Harefield Hospital, waste store - planning application 9011/APP/2018/18541 message

5270 PL-003 Bin Store Plan and Elevations REV B - Scan.pdf
1019K

P Ground Floor Plan as Proposed
PL-003 SCALE: 1:50 @ A1

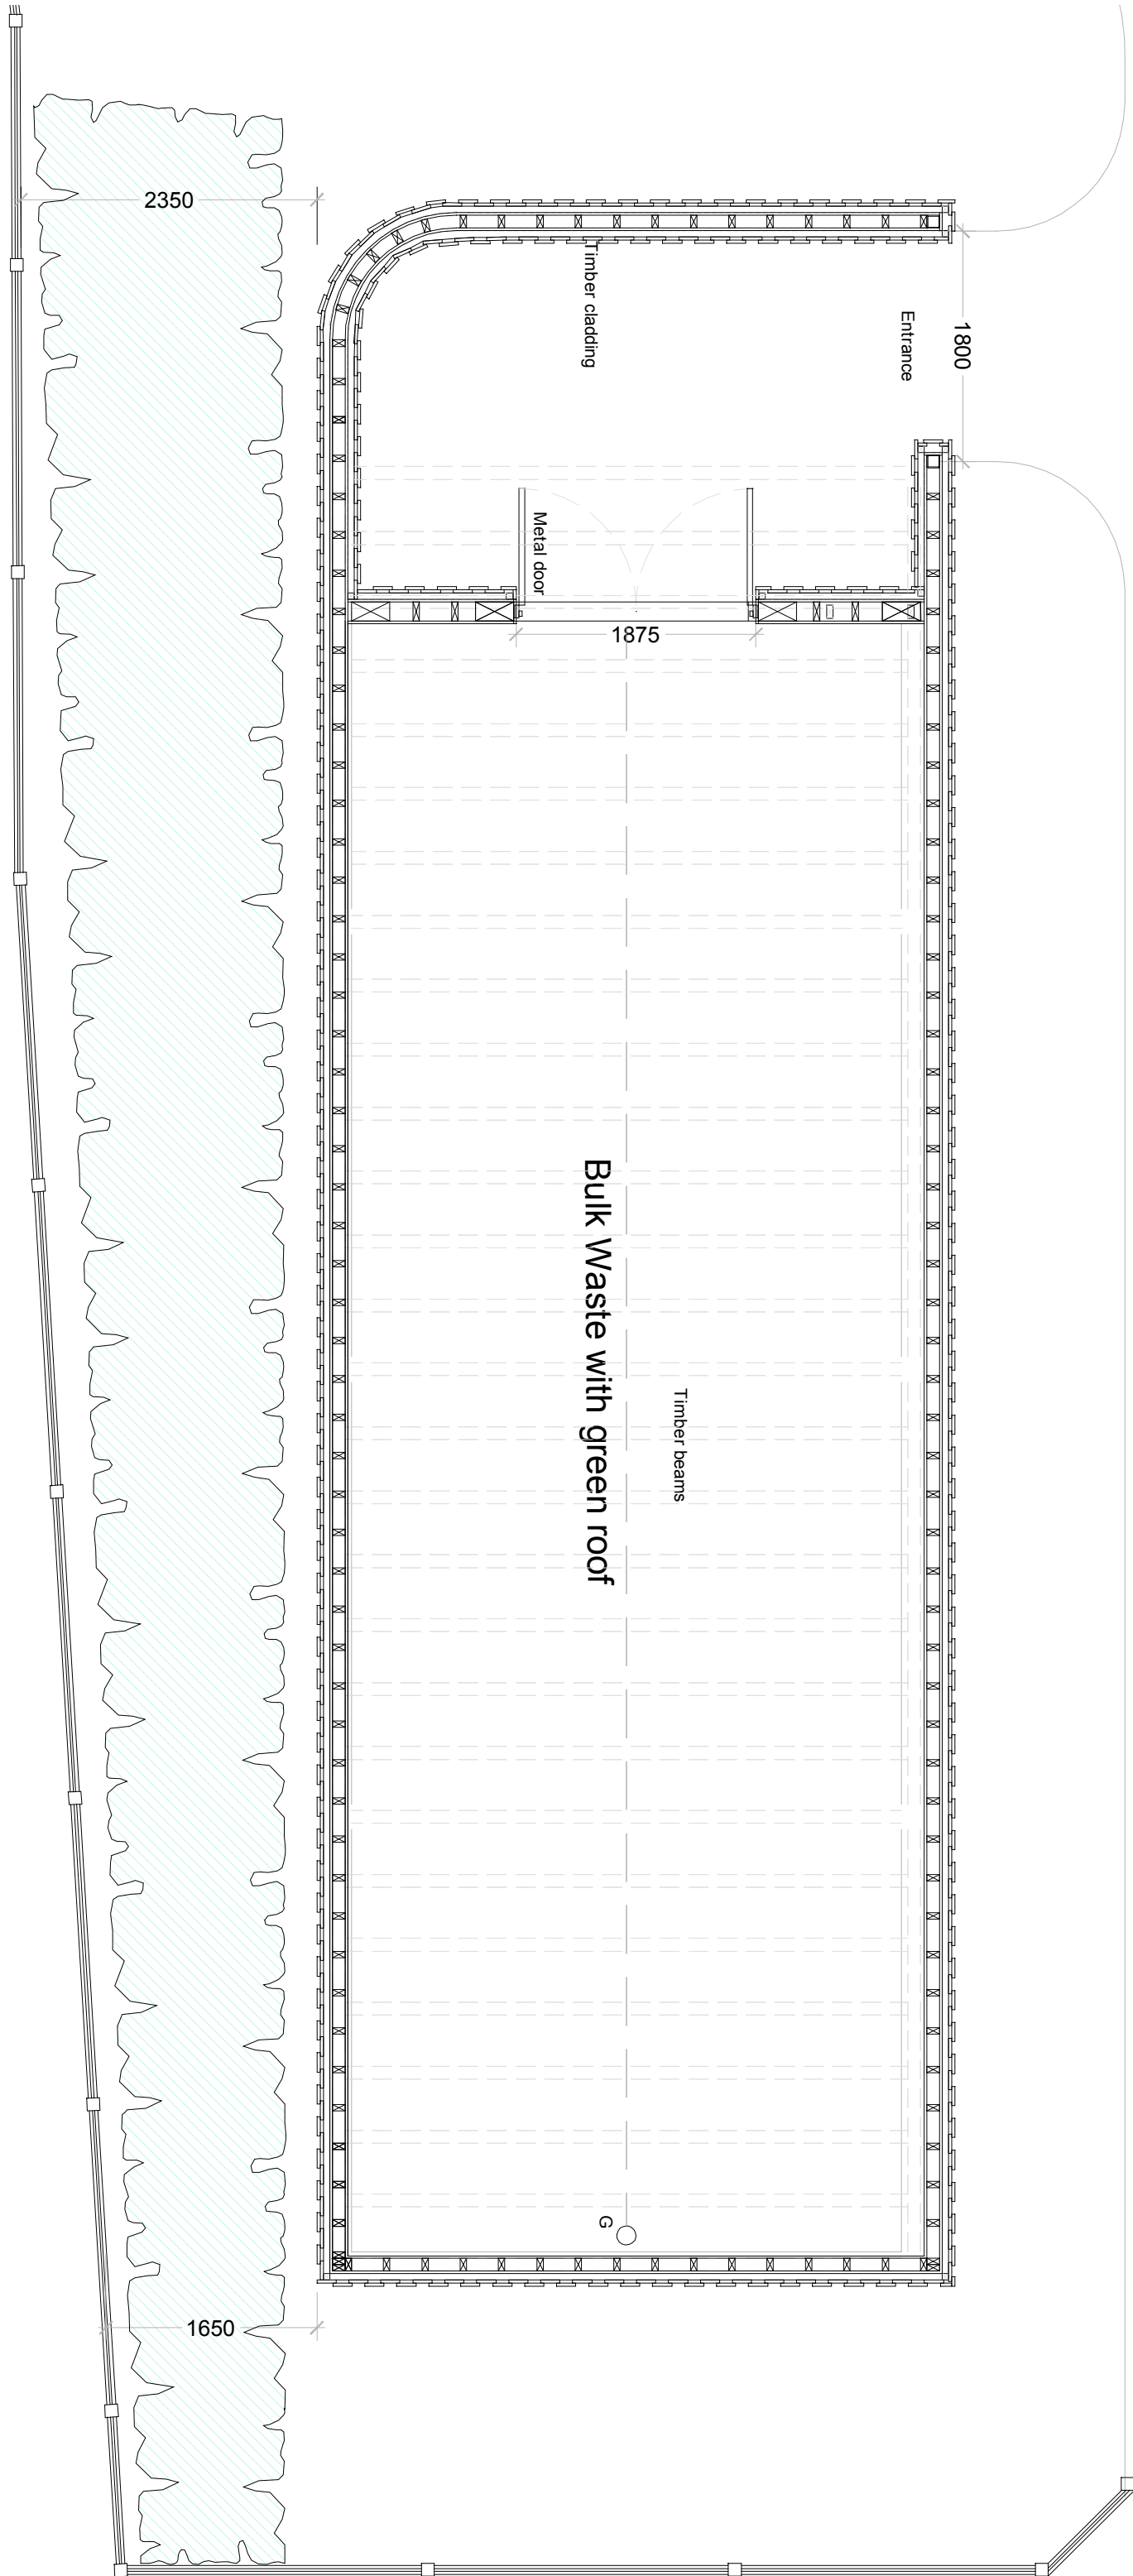
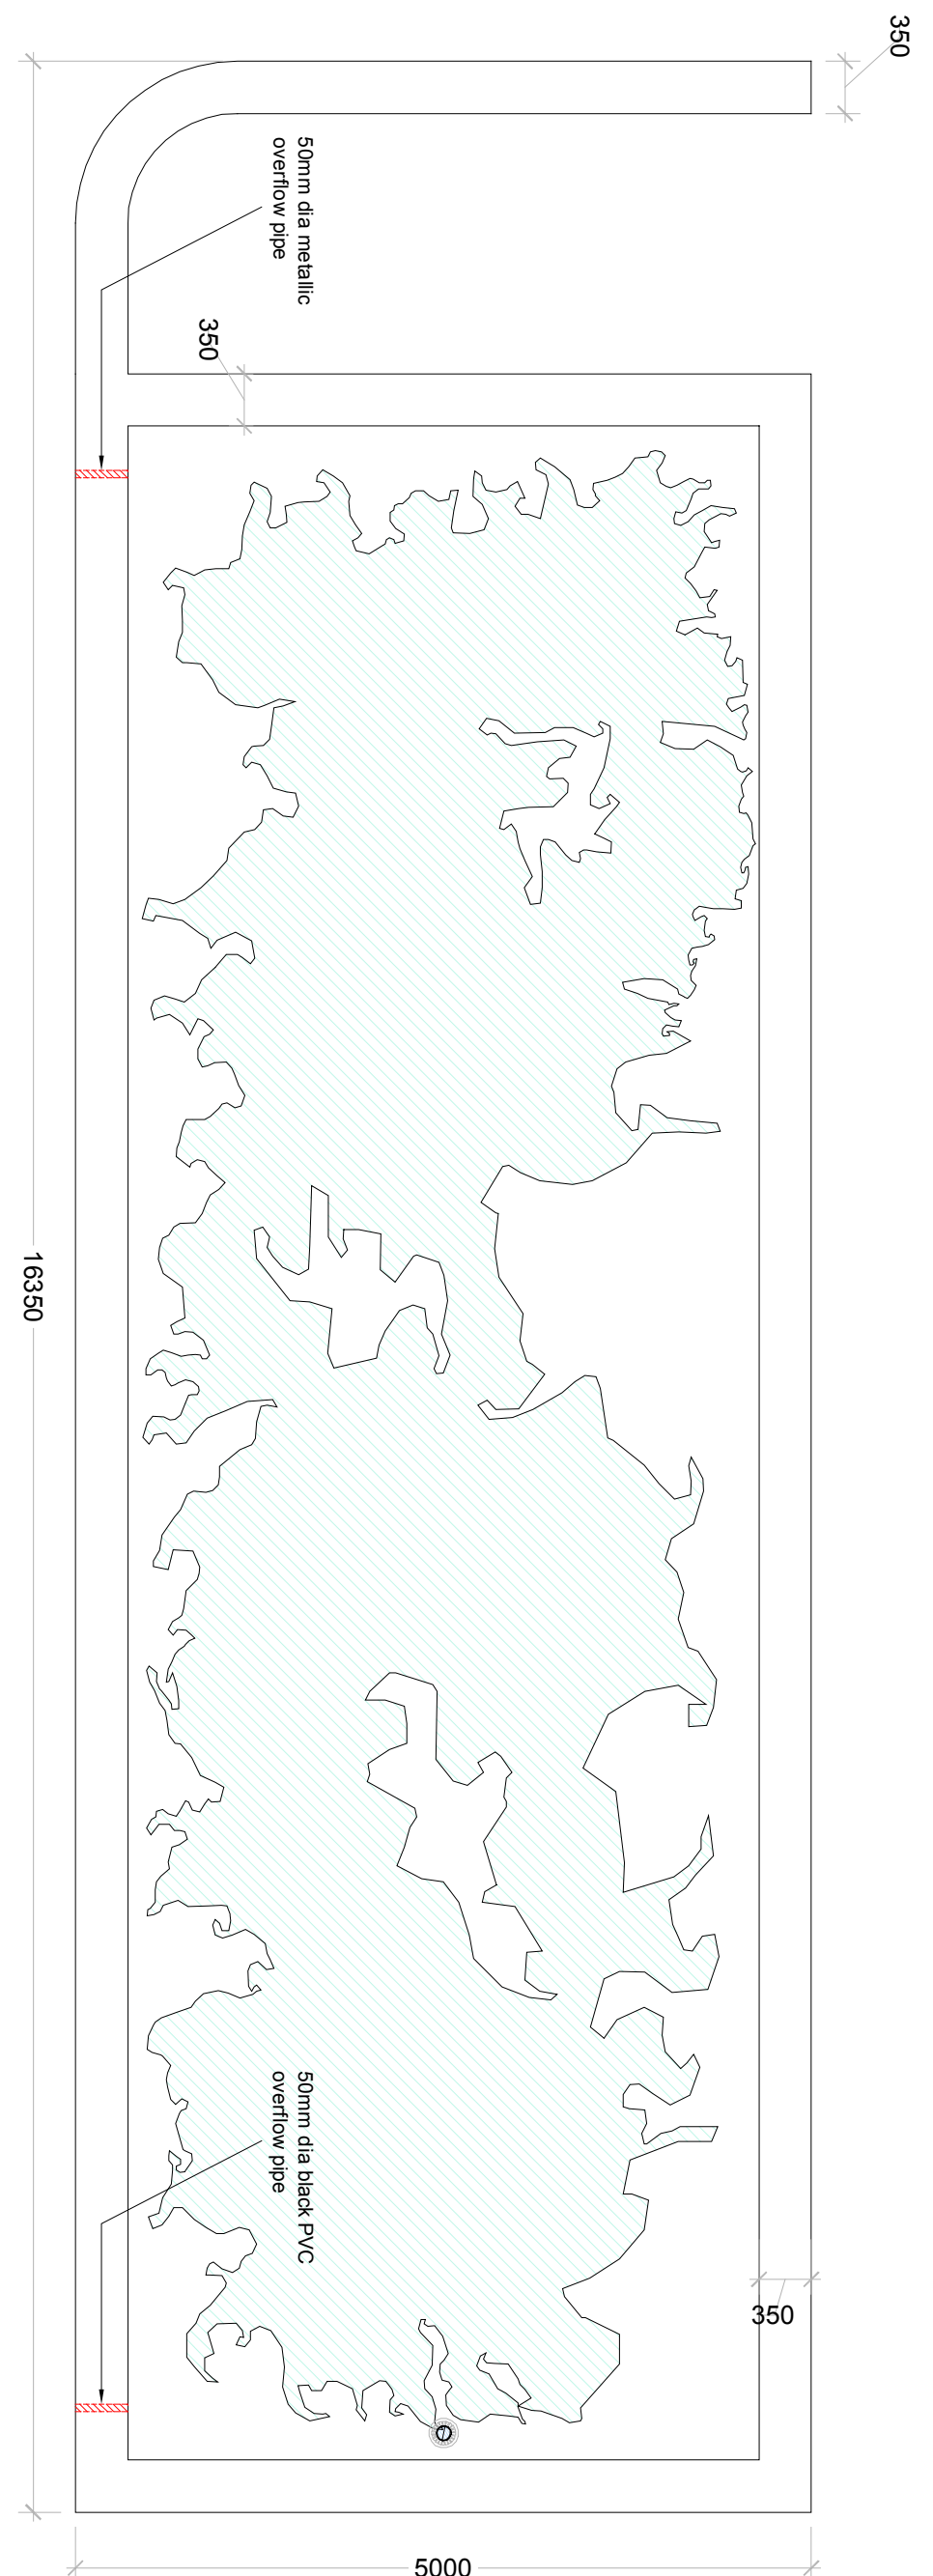
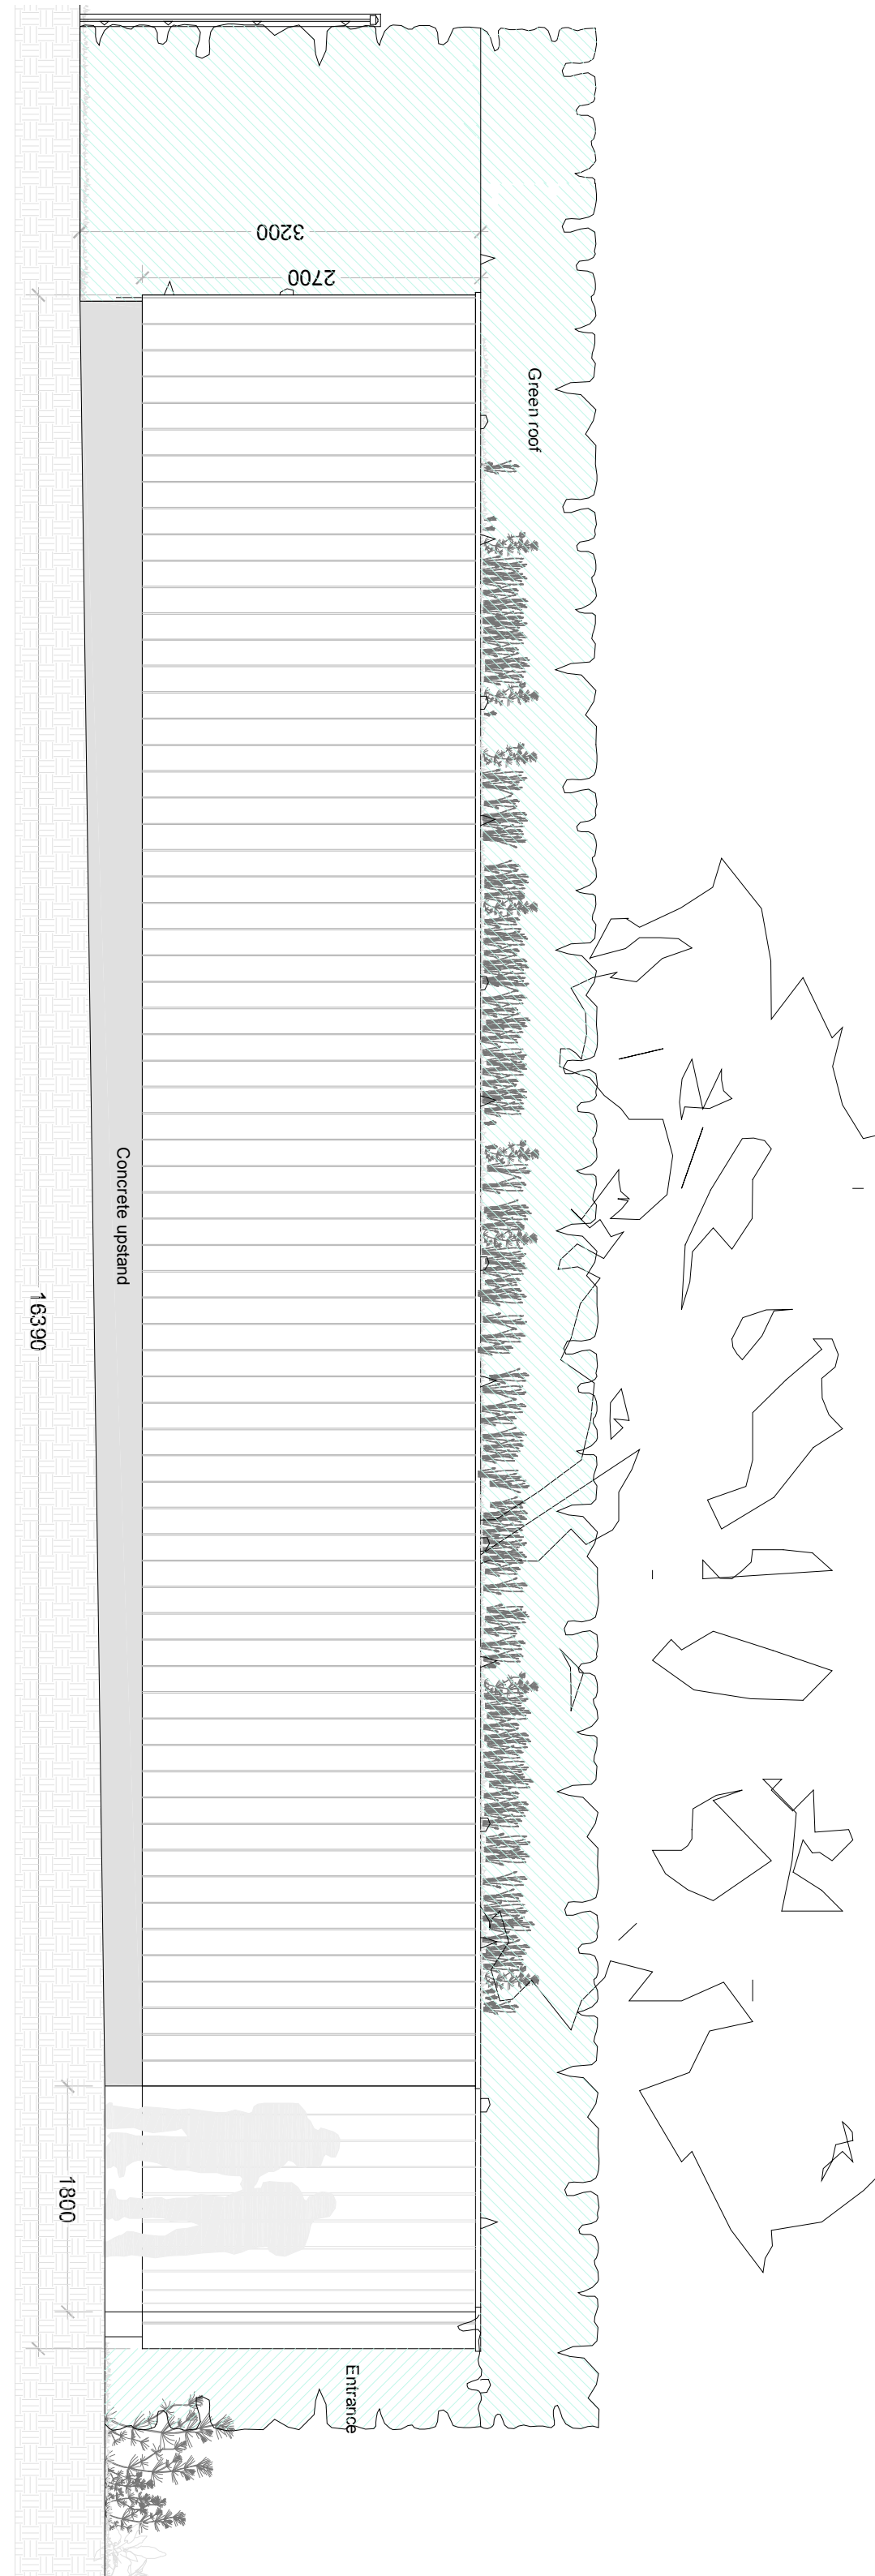
I have attached a pdf of the revised plan showing taller planting to the street side and end of the store and lower level planting to the gap between the store and the internal path.

For the taller planting I would suggest going with a native mixture of 20% Hazel (*Coryllus avellana*), 30% Hawthorn (*Crataegus monogyna*), 20% Blackthorn (*Prunus spinosa*), 10% Crab Apple (*Malus Sylvestris*), 15% Field Maple (*Acer campestre*) and 5% Dog Rose (*Rosa canina*). These would be bare root, approx 1.5m high when planted and slightly staggered at 4no. per metre. We would recommend the use of a mycorrhizal fungi, such as Rootgrow, to aid growth.

For the low level planting I felt we could use various masses of Rosemary (*Rosmarinus officinalis*) – 5l pots, Lavender (*Lavandula angustifolia* 'Hidcote') – 5l pots - and Potentilla yellow (*Potentilla* Yellow) – 2l pots.
